MR & MRS J SUMSION

## DEADLINE 9 SUBMISSION

As requested by the Examining Authority, we are writing with a closing statement on outstanding matters not resolved by the end of the Examination as follows:

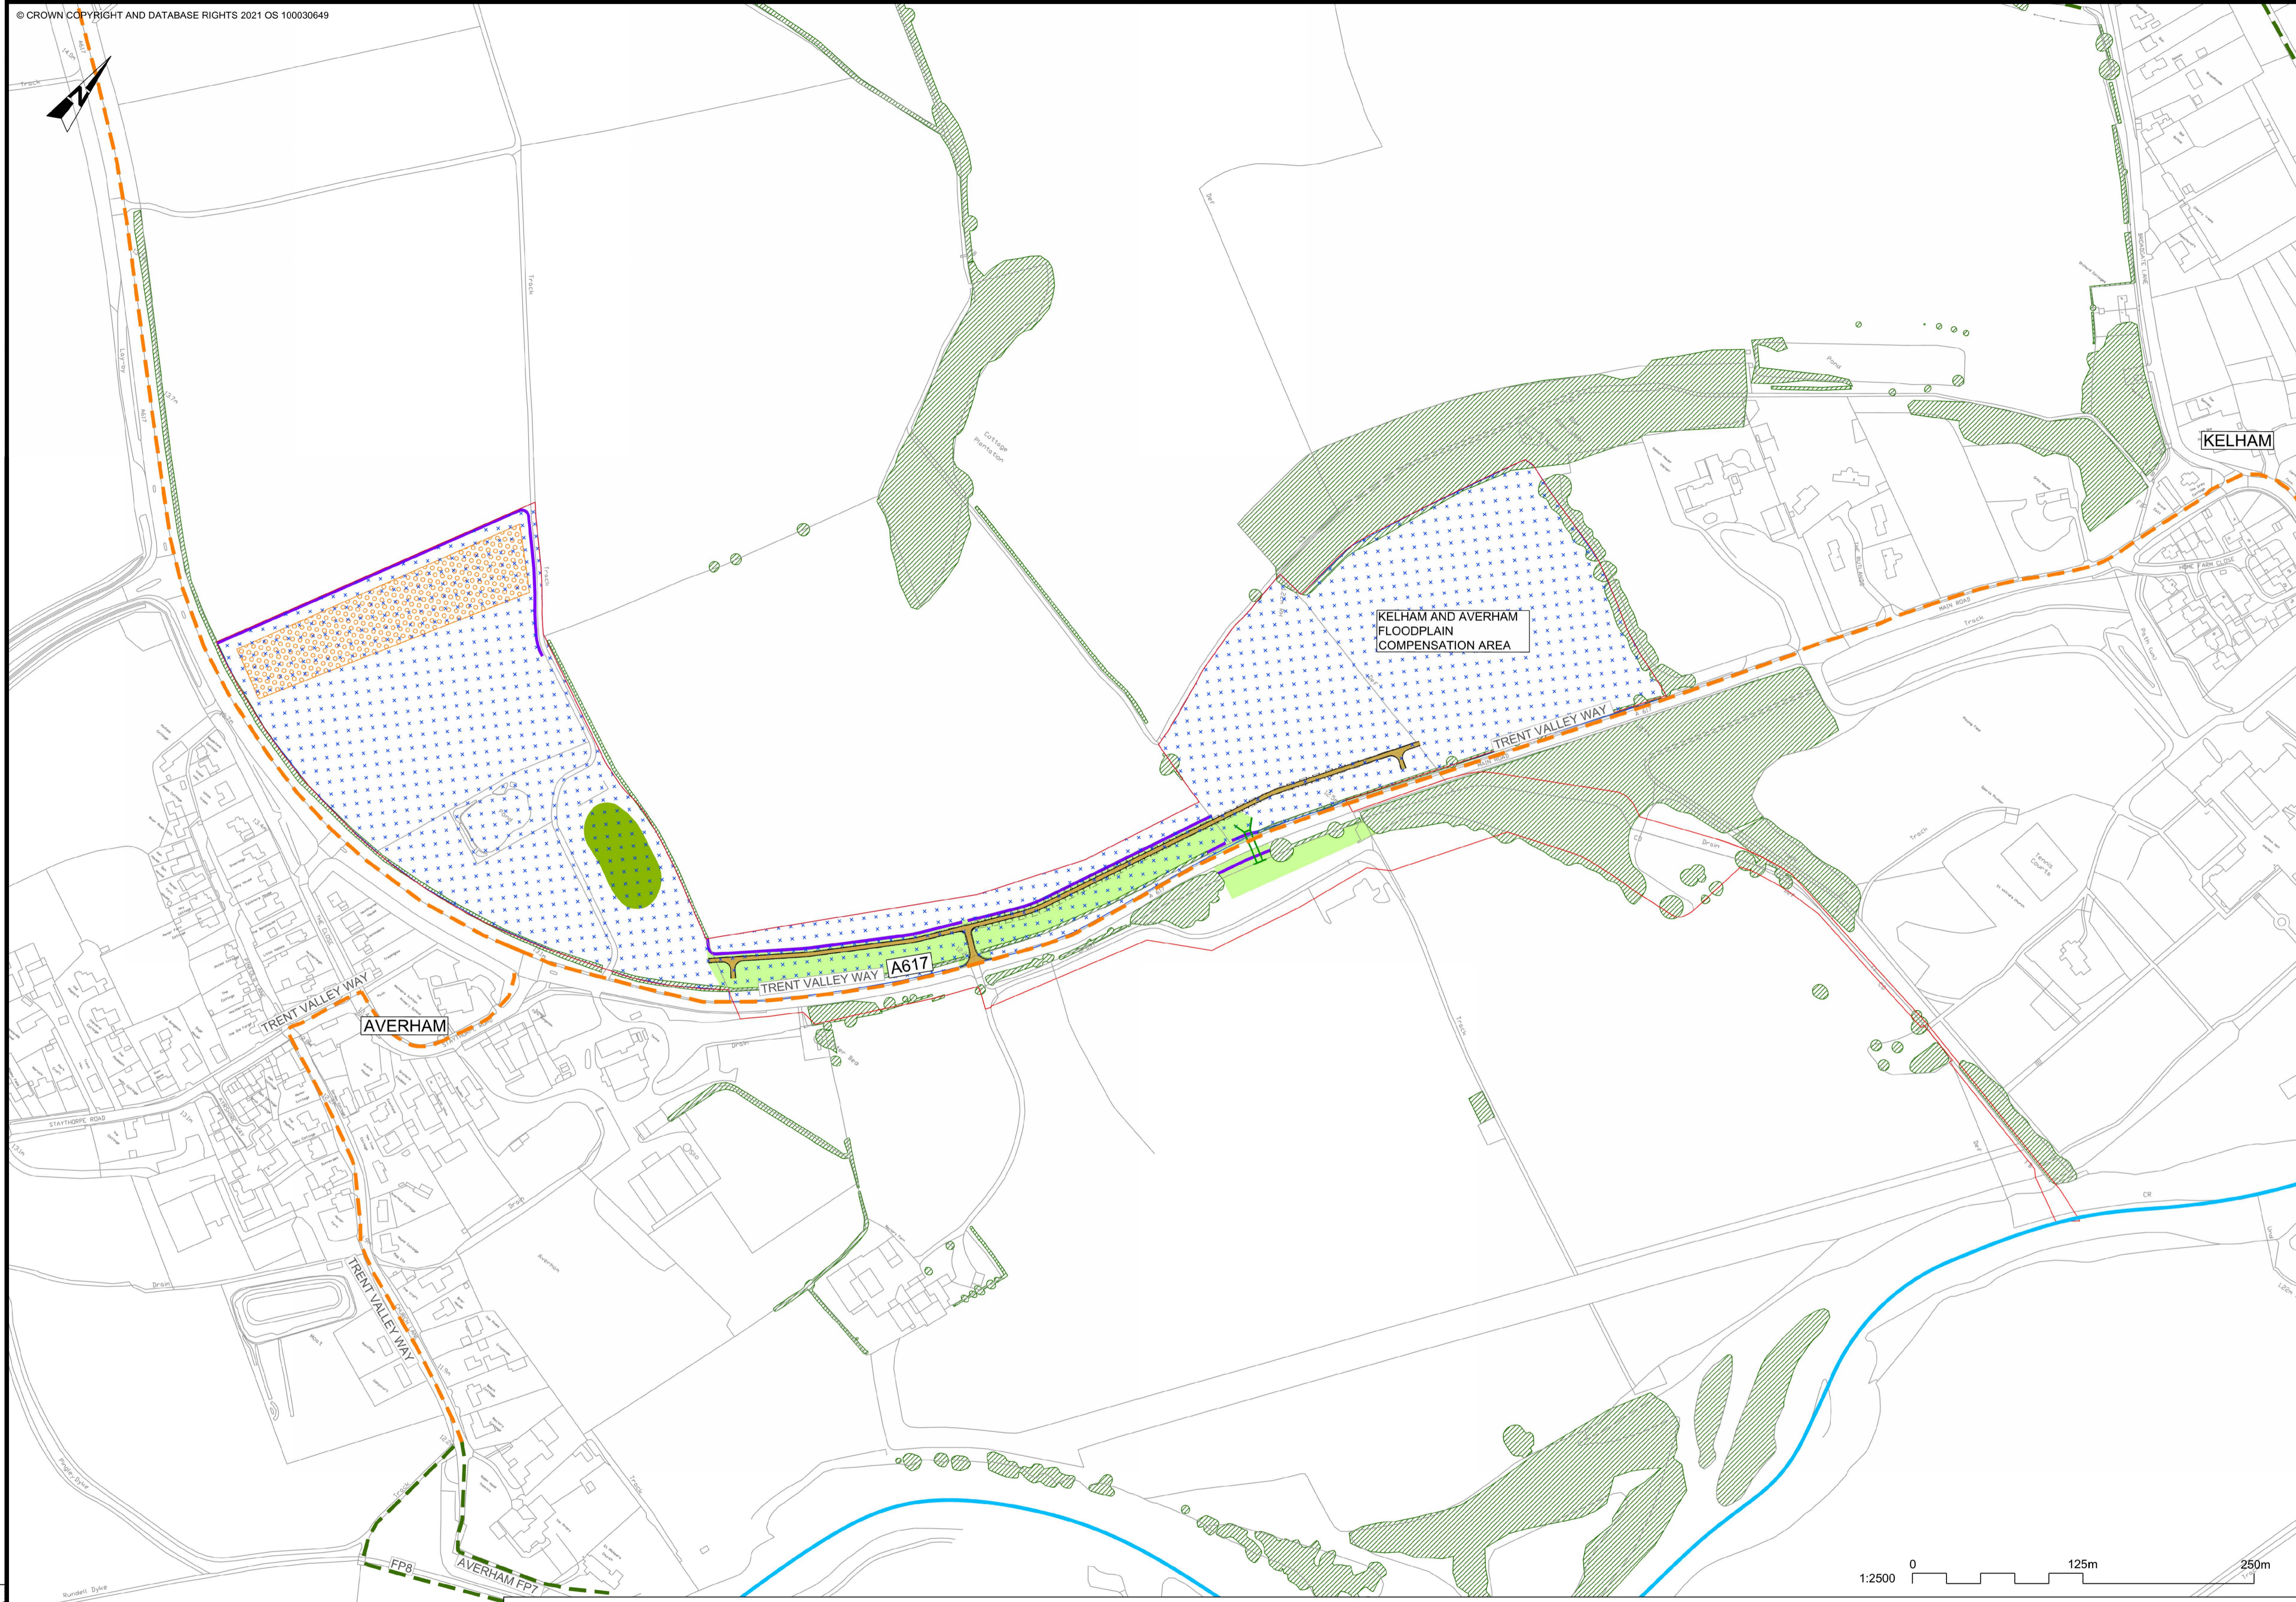
As shown on the General Arrangement Plan (Ref: Regulation 5(2)(o), (5)(2)(p) and 6(2) Sheet 6 of 7 the new footpath located to the north east of the Winthorpe Roundabout finishes just short of an access road to the proposed balancing pond.

We suggested in our formal submission at deadline 2 (and as we have proposed to NH during our discussions) that the new footpath should be extended to meet with the new entrance point of ██████████ and the realigned A1133.

We wish to draw to the Examining Authority's attention that this has been included in a revised version of the General Arrangement Plan by NH (as attached) showing the extended footpath section.

As part of our closing statement, we request that the Examining Authority formally request this change as part of the application under consideration.
